Application number: 2020/62/94285/E	
What is the application for?:	Alterations to office building to form 20 flats and associated office space and
Address of the site or building:	22-26, Wellington Road, Dewsbury, WF13 1HL
Postcode:	BD5 0BS

User comments

PROPOSED GROUND FLOOR PLAN

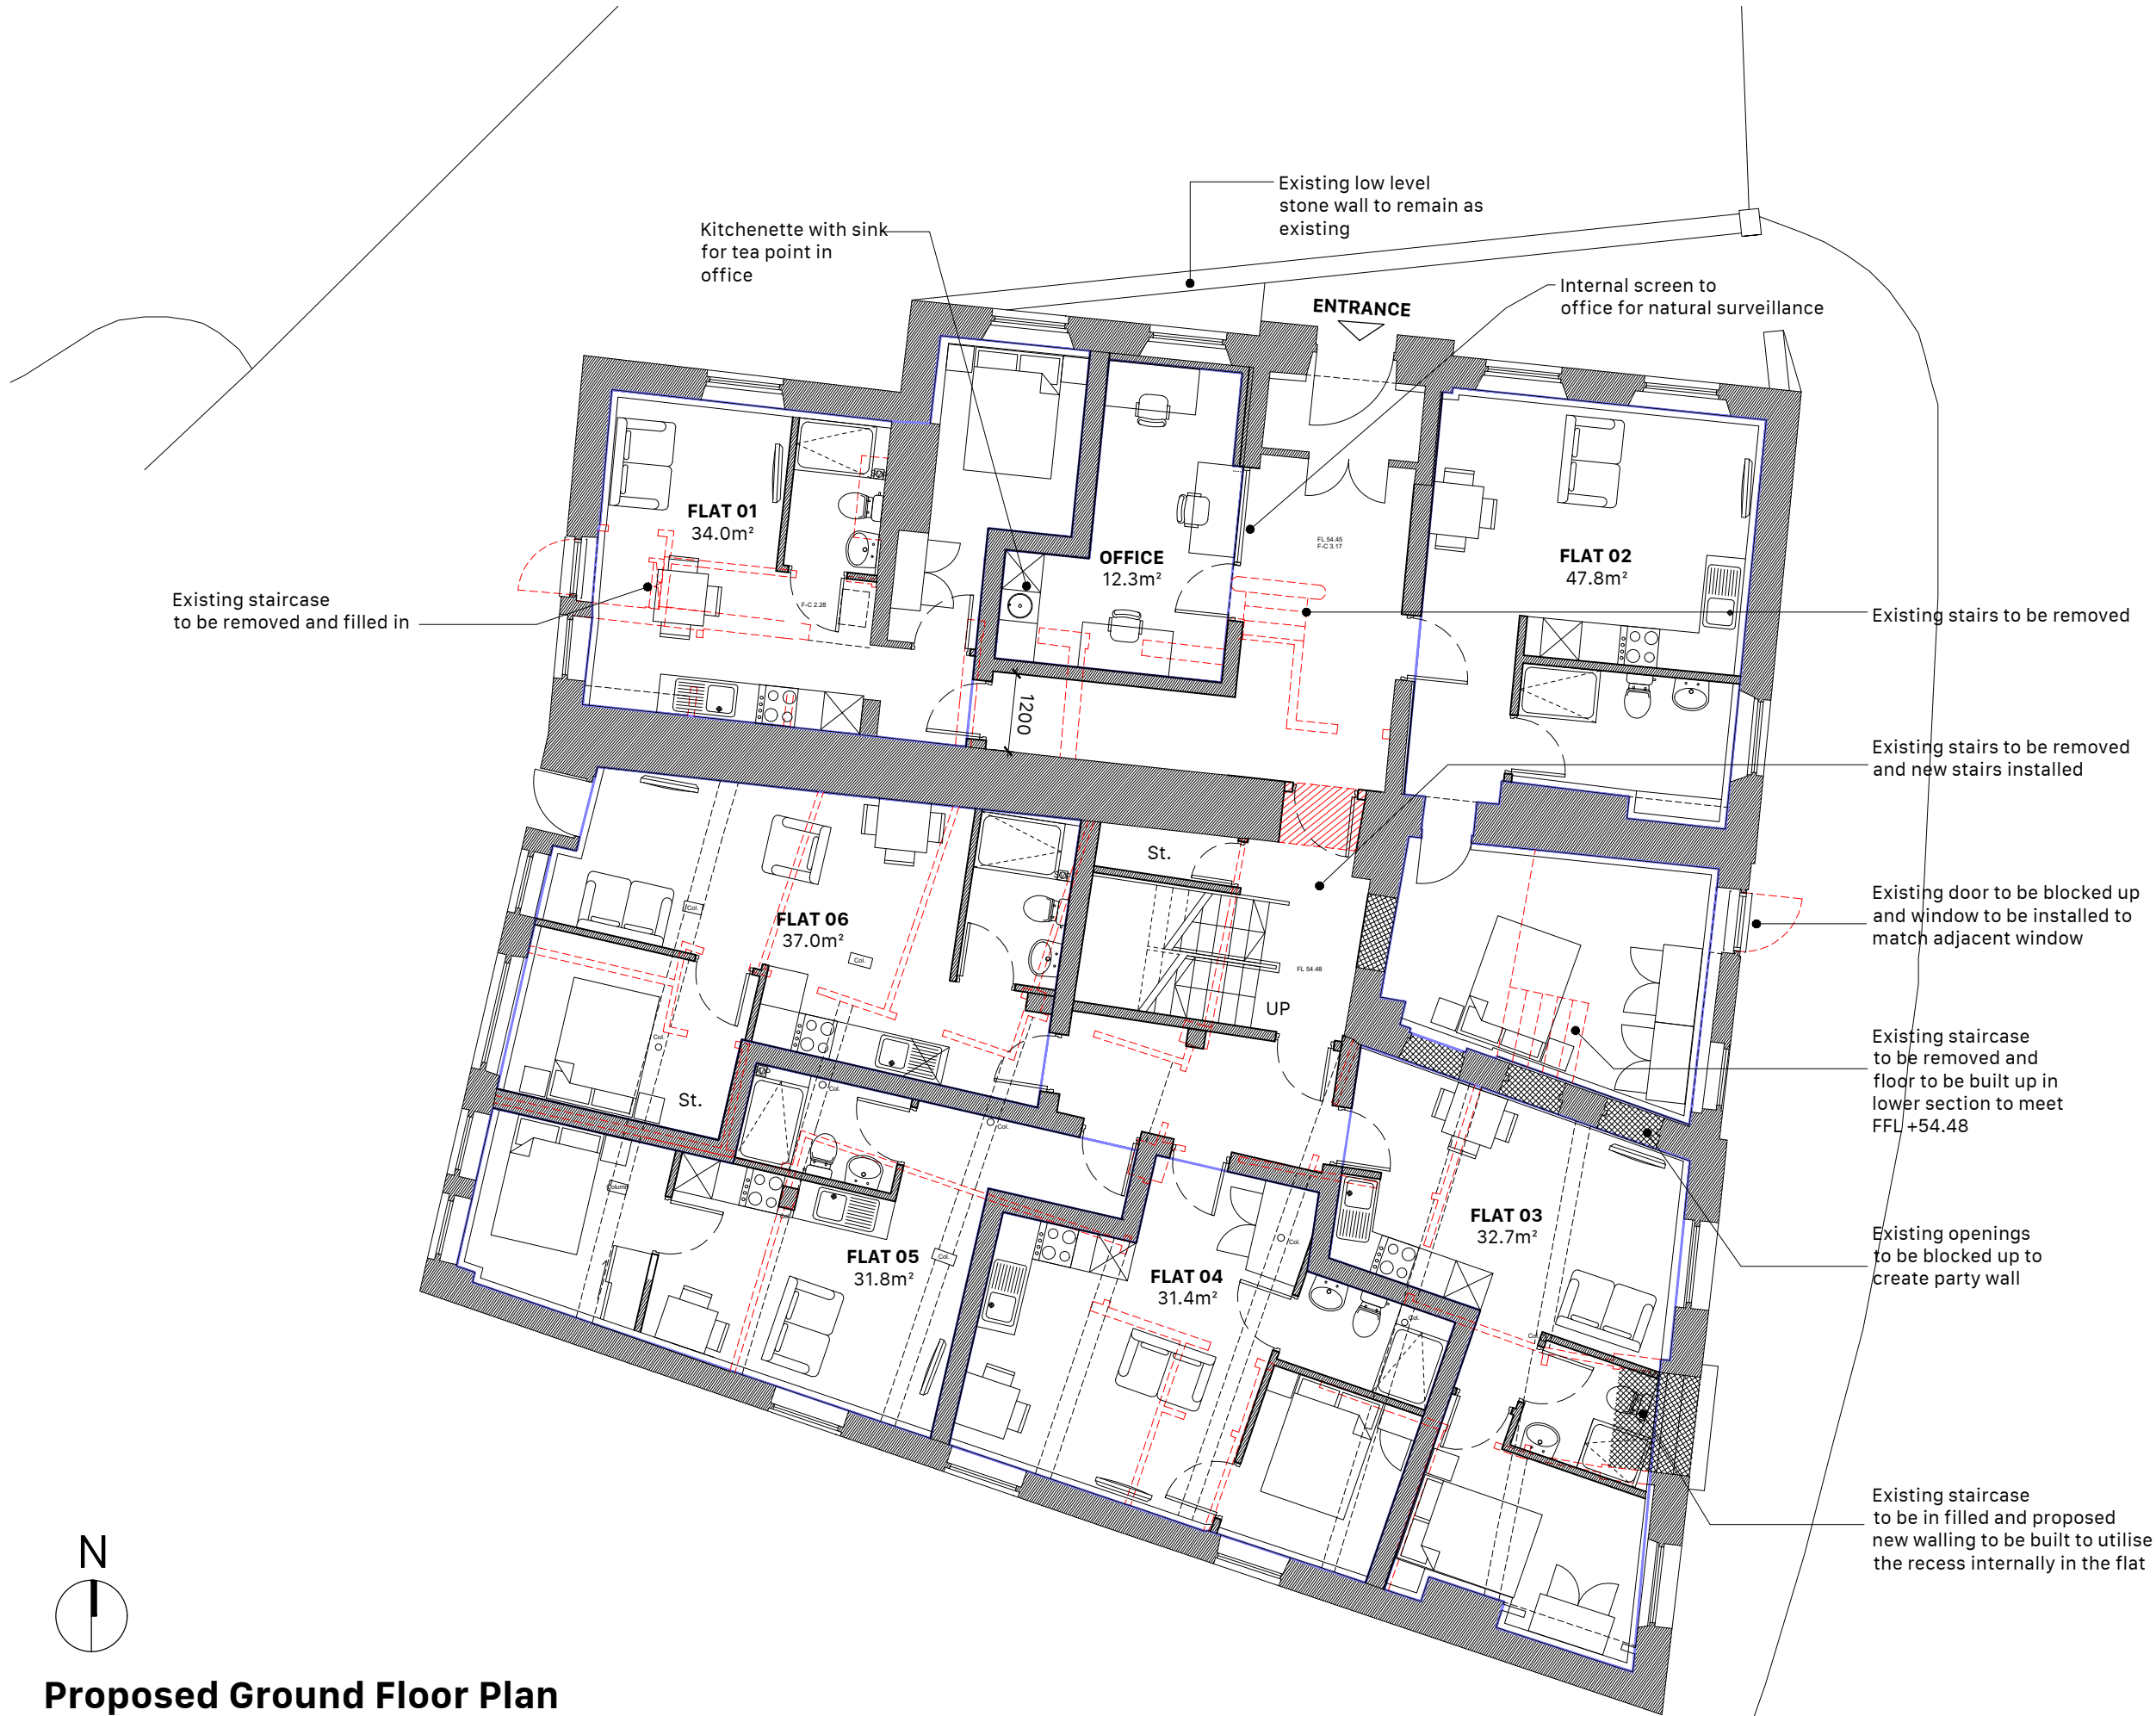
Type of comment: A general comment	
Do you wish your comments to be published on the website anonymously?	Yes
I refer to the above application and would like to make the following representation. A. There does not appear to be provision for a bicycle store. B. There does not appear to be a provision for refuse store. C. The use of aluminium for windows in a heritage building seems perverse and research should be given to Accoya timber which will give 60 years life span. D. In this highly prominent position with views from the railway and a busy road a planning condition should be placed on the window treatment with blinds specified. This will hopefully prevent the occupiers use of cardboard/newspaper or other inappropriate window dressings. E. Now is the time to formulate and implement a Masterplan for this area of Dewsbury that sets future housing policy for the area.
